KITTITAS COUNTY COMMUNITY DEVELOPMENT SERVICES

January 4, 2010

RE: Lower Green Canyon Short Plat (SP-09-00015)

The Kittitas County Community Development Services Department has determined that the Lower Green Canyon Short Plat (SP-09-00015) is a complete application and hereby grants *conditional preliminary approval* subject to the following conditions:

SHEET 1 OF 3

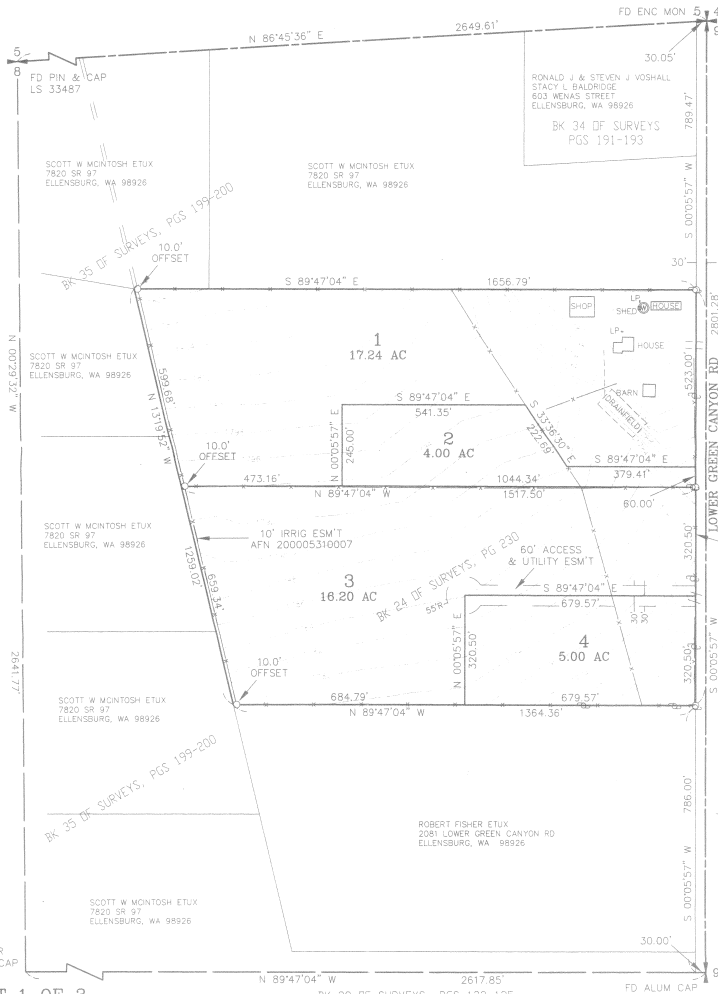
1. Both sheets of the final mylars shall reflect short plat number SP-09-00015 and an accurate legal description shall be shown on the face of the final plat.

11. All lots of the Lower Green Canyon Short Plat have a PEMC wetland across the east end of the properties. The final mylars shall reflect the location of this wetland and a statement on the plat shall read as follows: "Future development of lots may require a study by a certified wetland biologist to determine wetland classification and for buffer requirements pursuant to KCC Critical Areas Code."
